# **Sheringham Shoal and Dudgeon Offshore Wind Farm Extension Projects**

Traffic and Transport Discussions with  
Norfolk County Council

Title:	
<b>Sheringham Shoal and Dudgeon Offshore Wind Farm Extension Projects Examination submission Traffic and Transport Discussions with NCC</b>	
PINS document no.:	
Document no.:	
Date:	Classification
<b>10.01.2023</b>	<b>Draft</b>
Prepared by:	
<b>Royal HaskoningDHV</b>	
Approved by:	Date:
<b>Sarah Chandler, Equinor</b>	<b>XX</b>

**Table 1-1 NCC Comments on SEP and DEP DCO documents and the Applicant's response**

**A148 BODHAM**

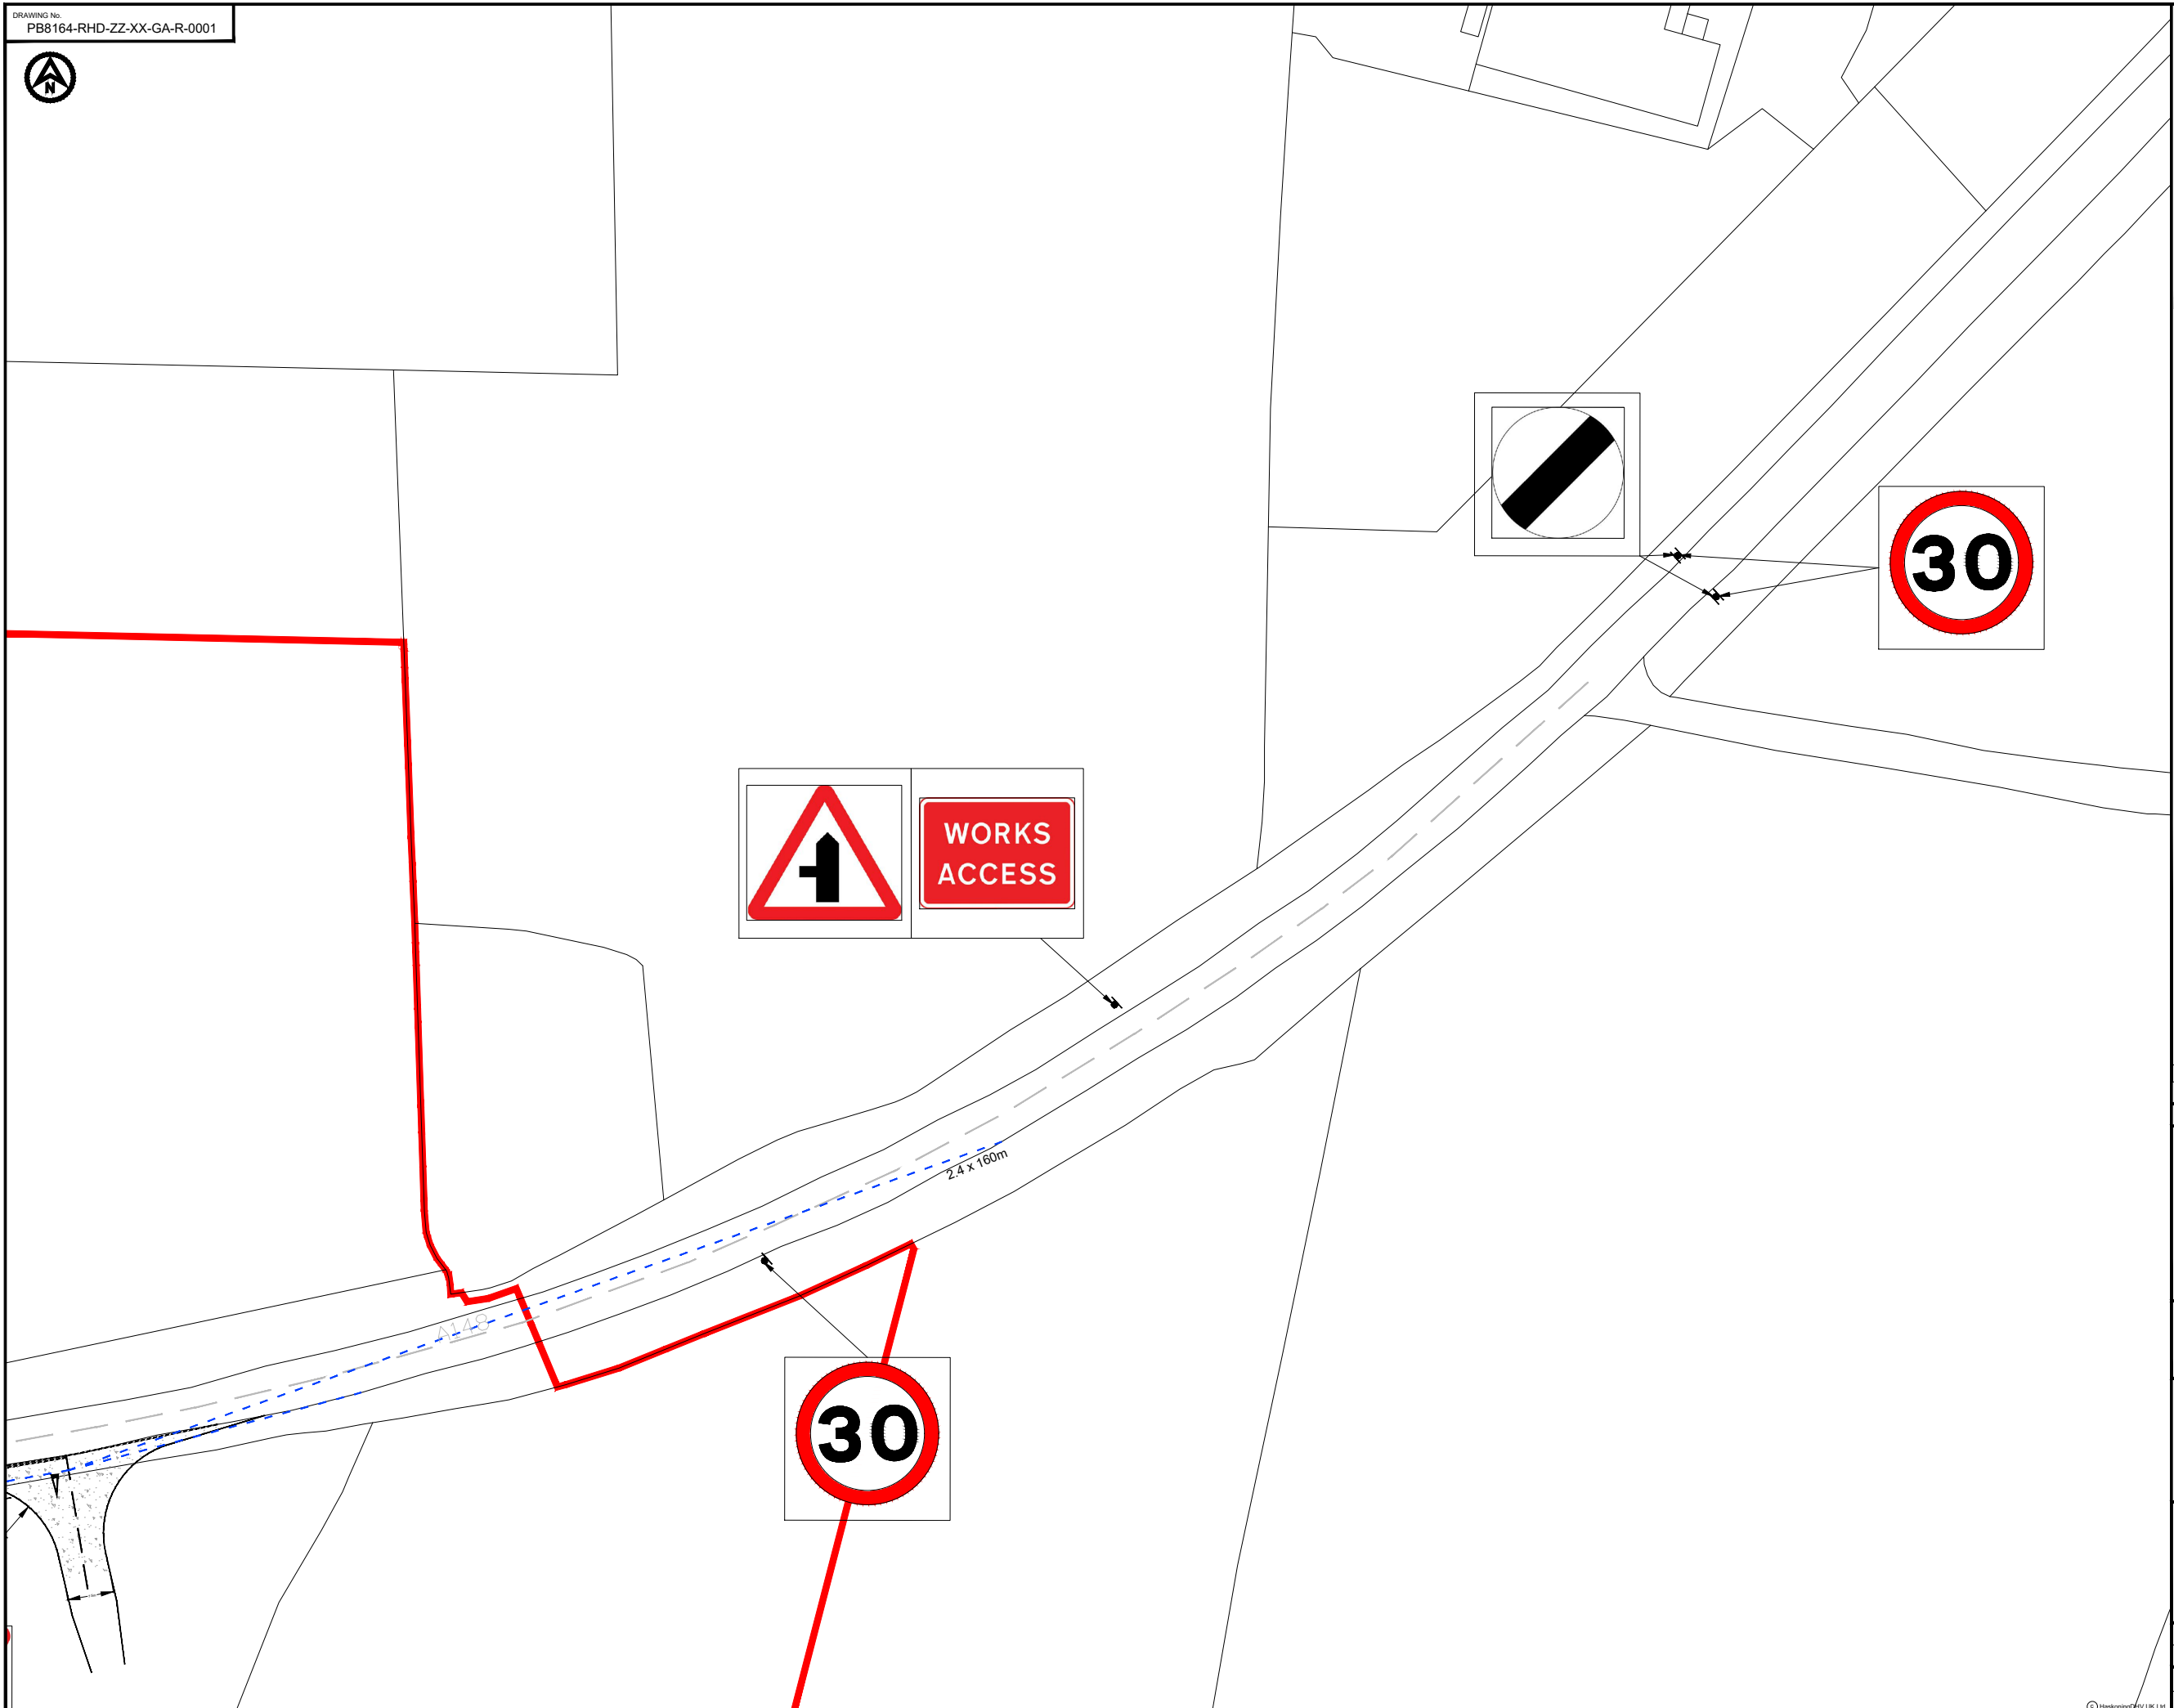
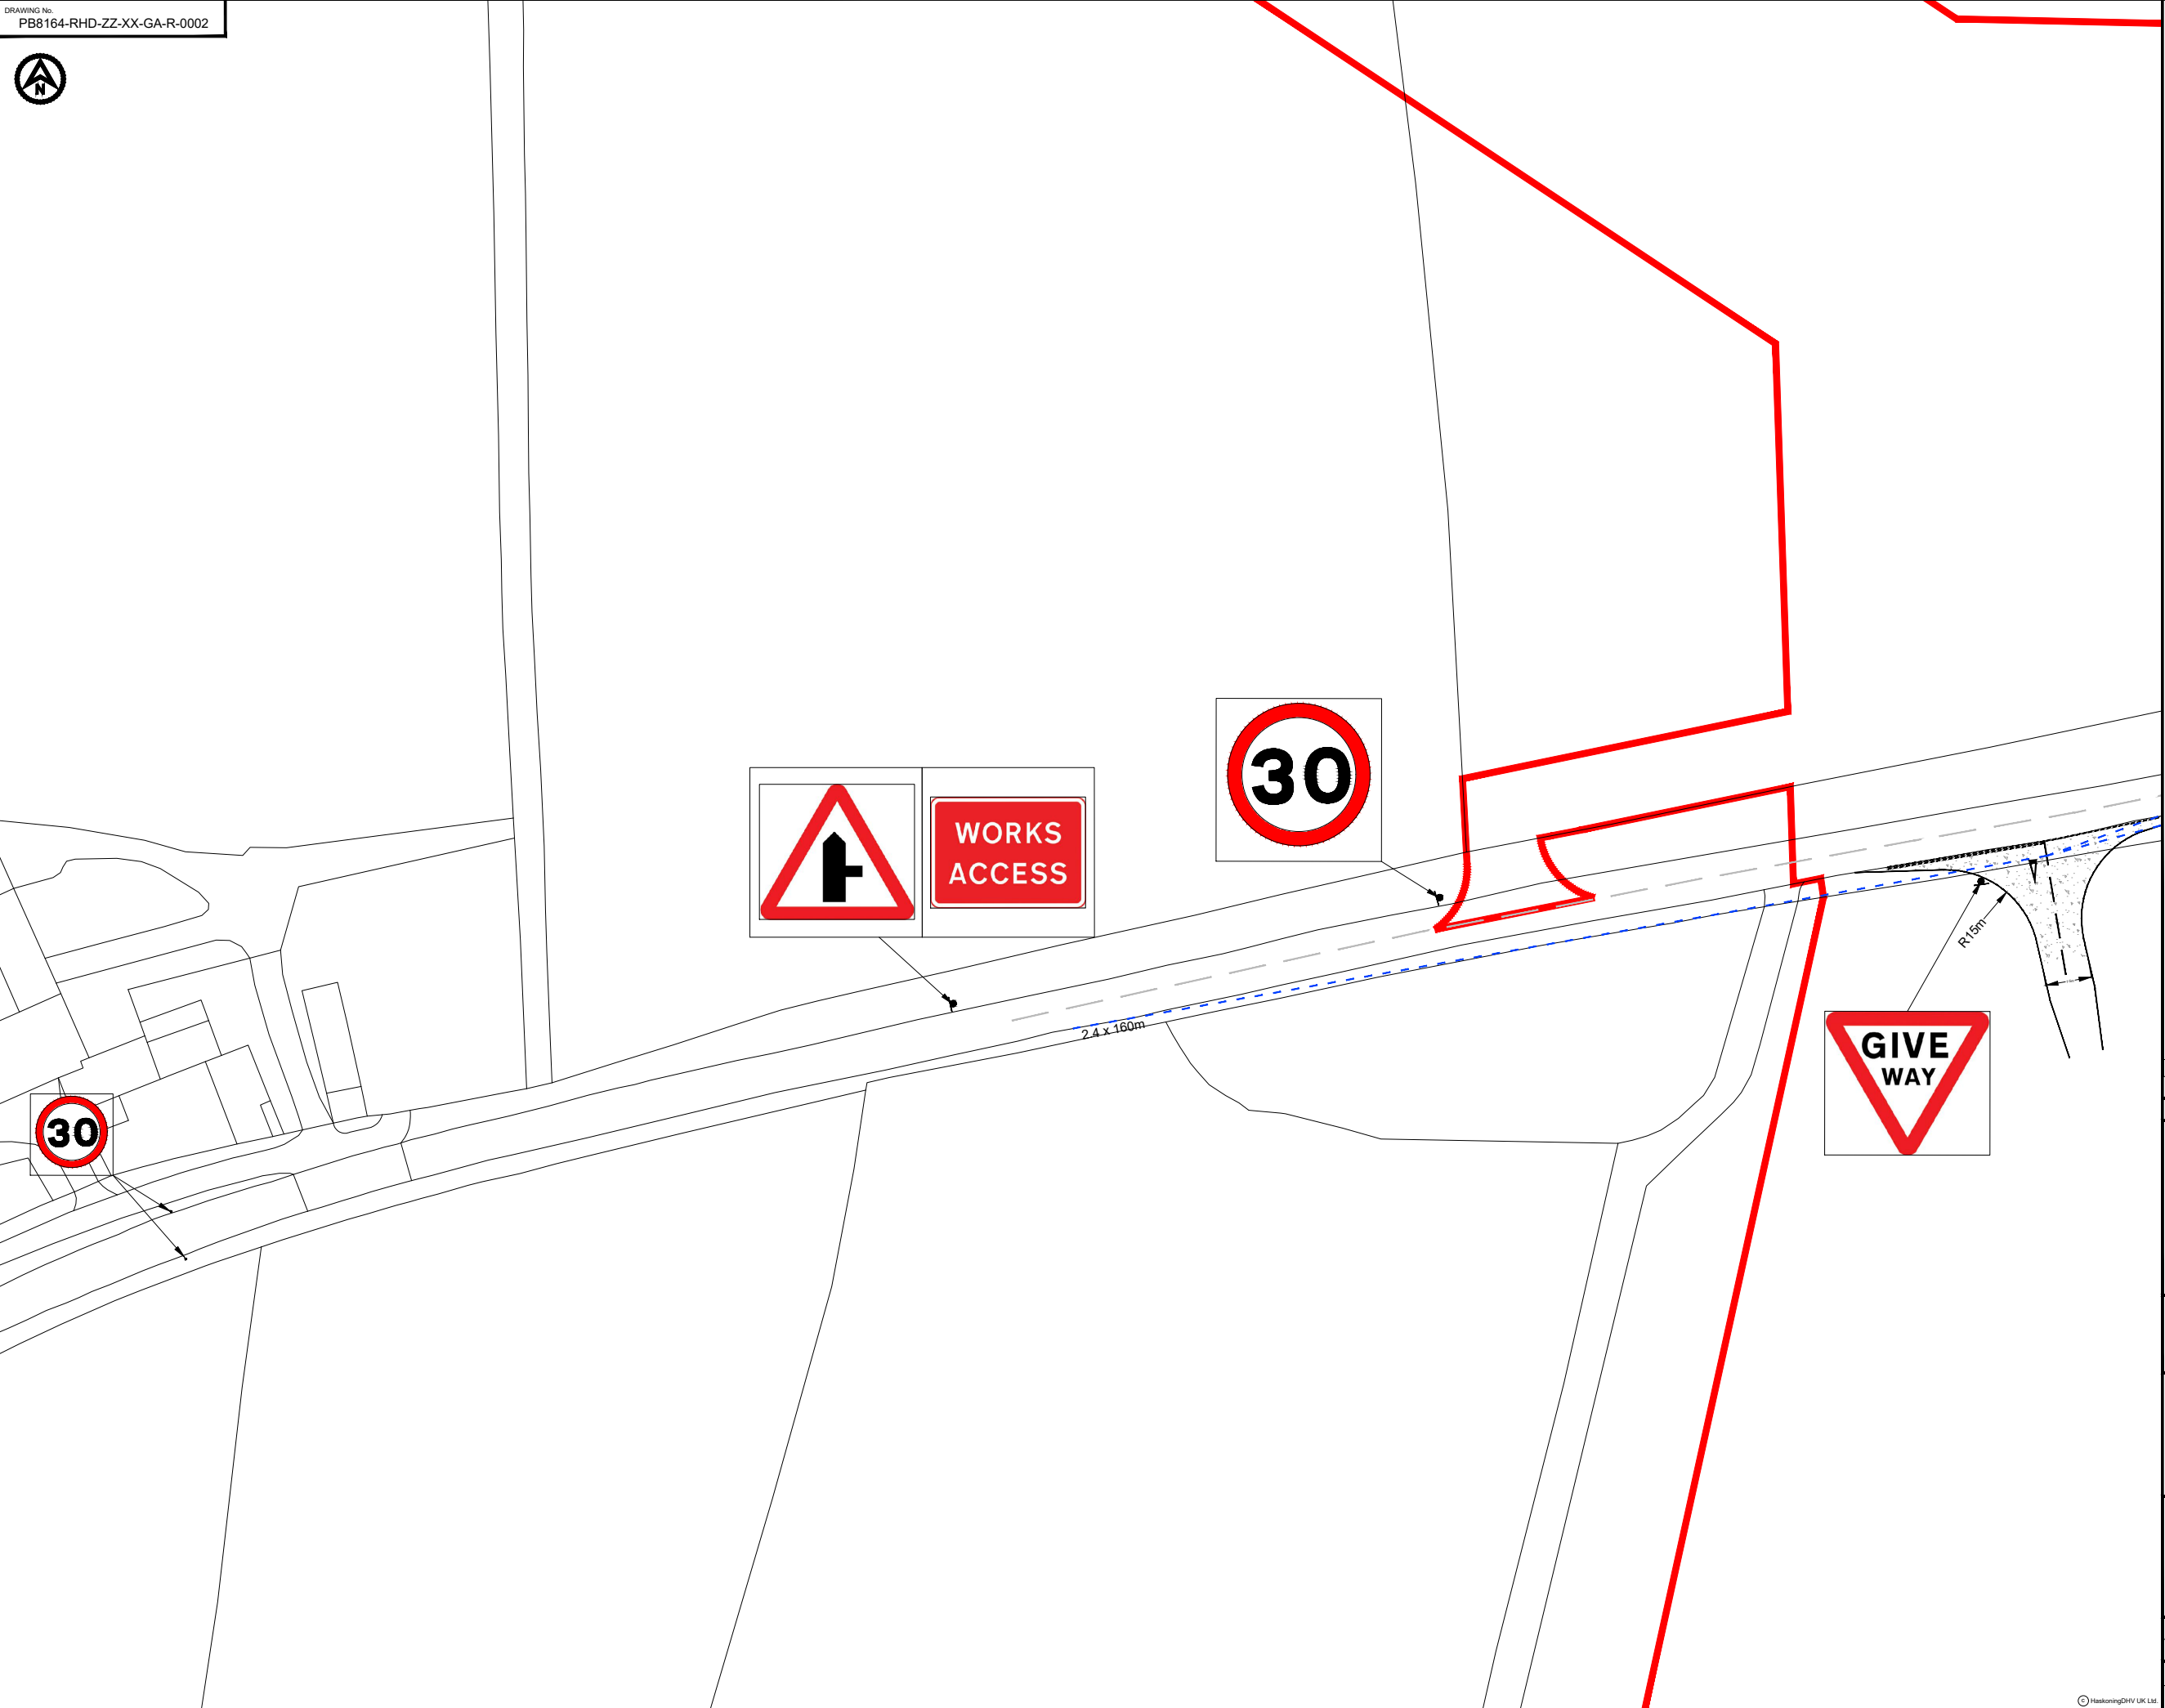
I.D.	NCC identified document, page, section number, etc.	NCC Comment	Applicant Response	Record of discussions with NCC
			responses (ID17 to ID21) present peak hour traffic flows for each of the identified locations in the context of this commitment.	
17		Sheet 5 Bodham Compound at A148 – need restrictions on traffic levels in the summer. In a 40mph.	Annex 19 of the TA [APP-269] outlines the forecast numbers of peak daily vehicle trips that could travel to ACC10. This identifies that at peak, there could be up to 49 HGV trips per day, equivalent to three arrivals and three departures an hour. In addition, Annex 23 of the TA [APP-269] identifies that there could be a peak of up to 64 LV trips per day, equivalent to 32 arrivals in the morning and 32 departures in the evening. When considering network peak hours and applying the existing commitments in relation to LV movements (detailed at ID.16) there could be a peak of eight LV and five HGV trips during the defined network peak hours. The Applicant considers that the existing substantive commitments in relation to managing LV trips would ensure that there are no significant impacts upon capacity at ACC10.	NCC confirmed that they are content with the clarification provided and that the measures outlined within the OCTMP to manage traffic movements are appropriate.
